Tween Bridge Solar Farm

9.12 Statement of Common Ground Canal and River Trust

Document Reference: 9.12

Revision 1

Figure 6.4: Landscape and Visual Mitigation Strategy

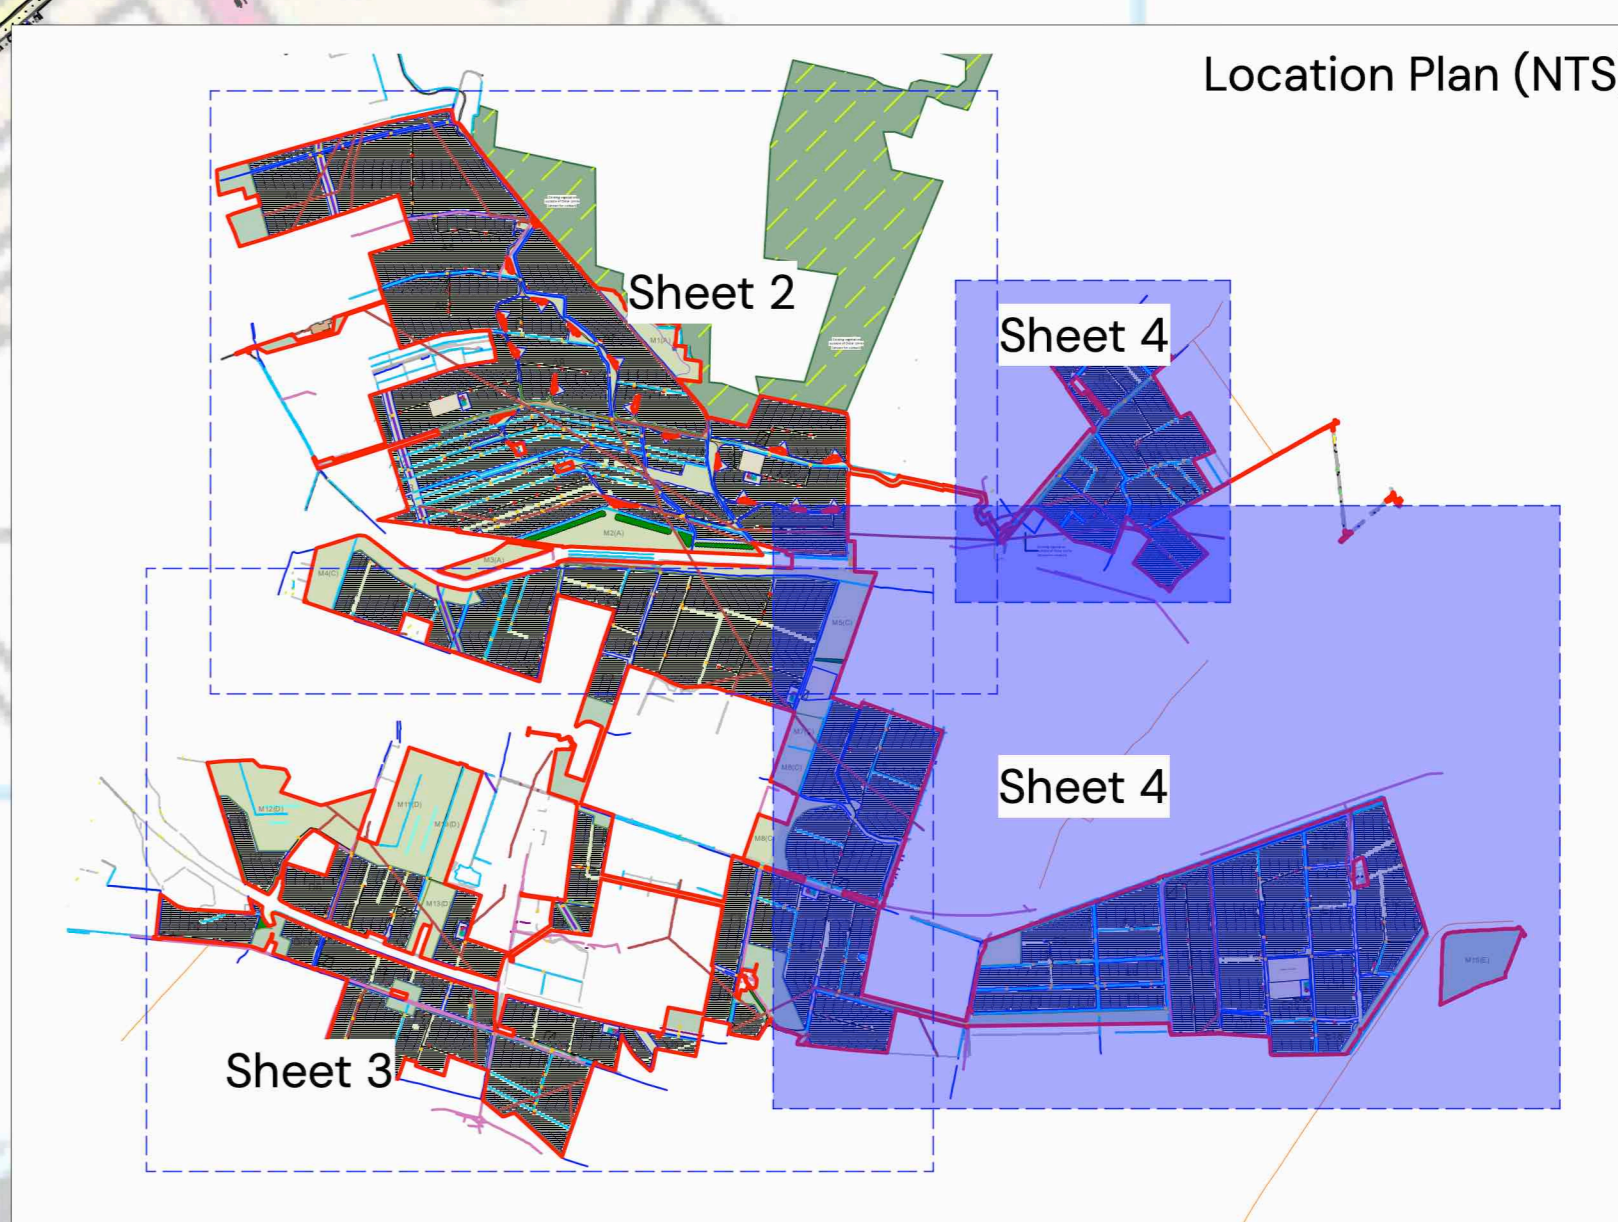
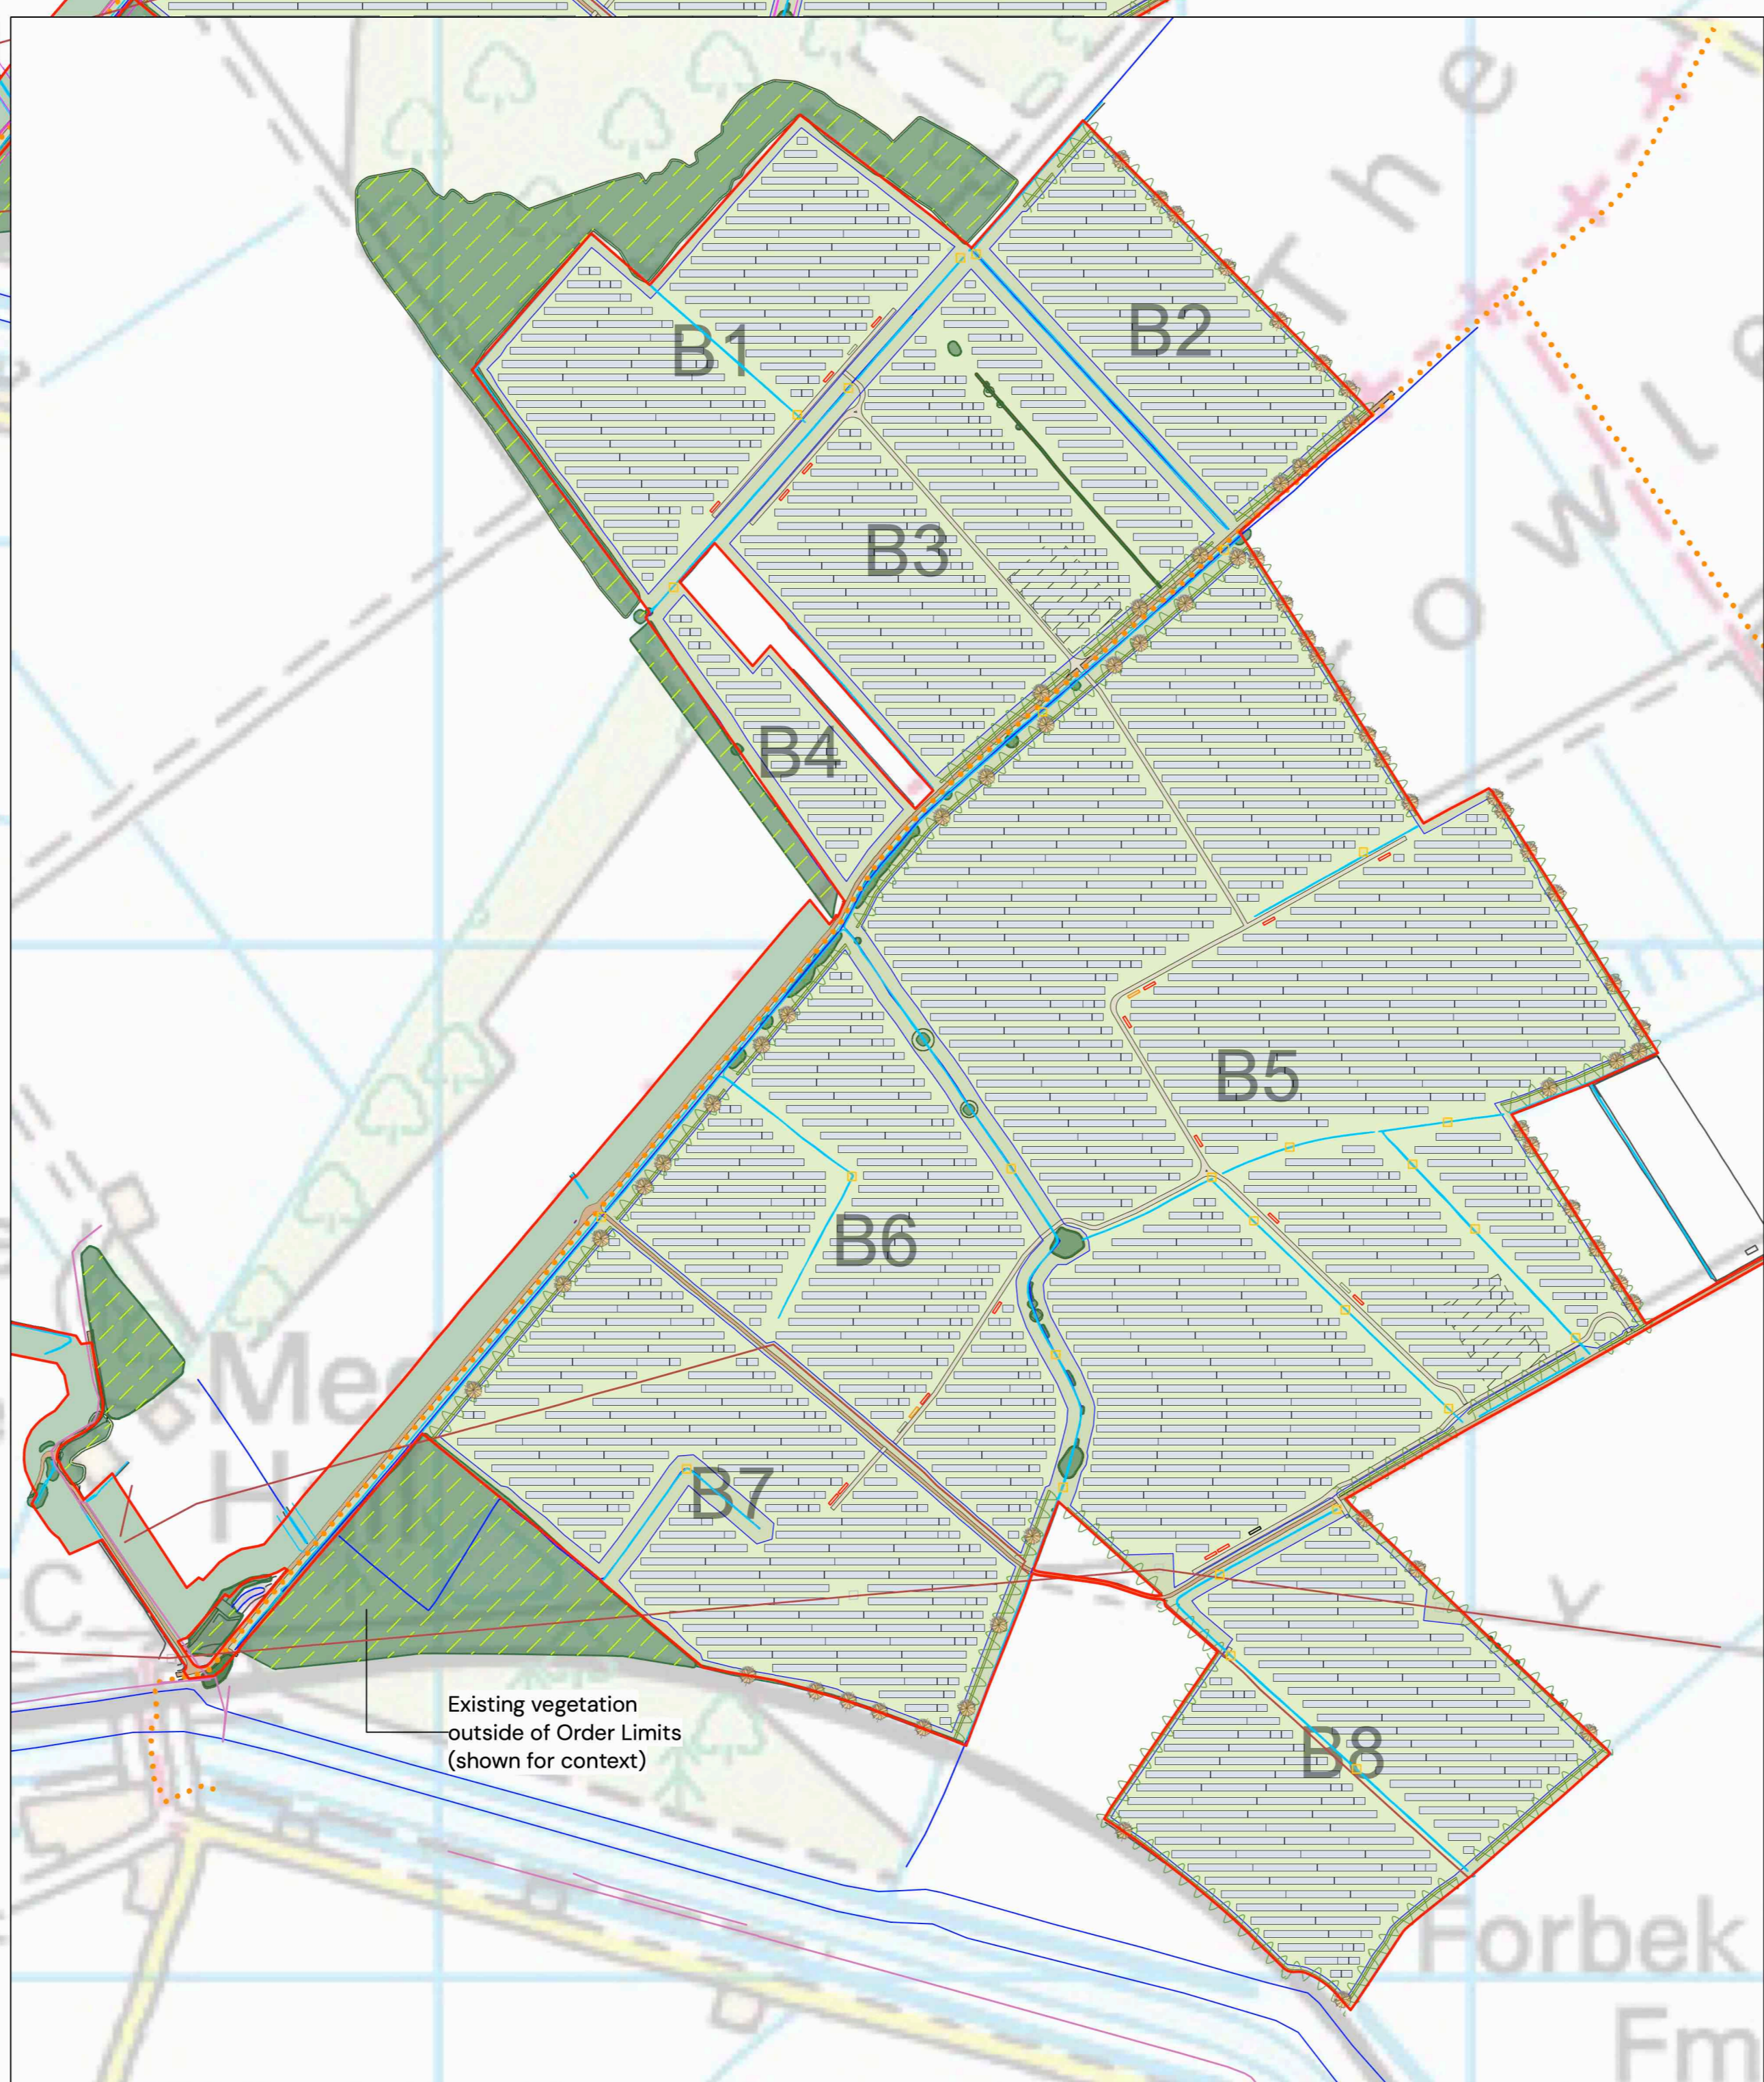
8.	Landscape and visual character – securing of mitigation for the Canal	The CRT requests that the measures highlighted in Figure 6.4 of the ES (Landscape and Visual Mitigation Strategy) [APP-148] are secured and implemented. Additionally, were the Landscape and Visual Mitigation Strategy to be capable of variation post-consent, the CRT would seek to be consulted on any variations affecting the impacts on the Canal.	Requirements 6 and 8 of the draft DCO [Document Reference 3.1 Revision 3]6] secure the Landscape and Visual Mitigation Strategy [Document Reference 6.4.6.4 Revision 24] . Specifically, requirement 6 controls the detailed design of the Scheme and requires that various design details be submitted for the approval of the relevant planning authority prior to each phase of development commencing. Such details must accord with the Landscape and Visual Mitigation Strategy, amongst other control	Under discussion

Ref	Topic	CRT Position	Applicant Position	Status
			documents. Requirement 8 sets out the requirement for a written landscape and ecology management plan to be submitted for the approval of the relevant planning authority prior to the commencement of each phase of development. Under requirement 8, the landscape and ecological management plan must be in substantial accordance with the Landscape and Visual Mitigation Strategy, amongst other control documents. The Landscape and Visual Mitigation Strategy is Figure 6.4 of the Environmental Statement, and therefore must be certified under article 43 of the draft DCO [Document Reference 3.1 Revision 3]6 and would be capable of variation post-consent. However, as confirmed by requirement 5, this would only be with the approval of the relevant planning authority and provided it had been demonstrated to their satisfaction that the subject matter of the approval would not give rise to any materially new or materially different environmental effects from those assessed in the ES. In the event a submission was made under requirement 5 in relation to the Landscape and Visual Mitigation Strategy, the Applicant anticipates that the relevant planning

Ref	Topic	CRT Position	Applicant Position	Status
			authority would consult the CRT in confirming its satisfaction that any changes proposed would not give rise to materially new or different effects. The Applicant requests confirmation from the CRT as to whether this matter is now agreed.
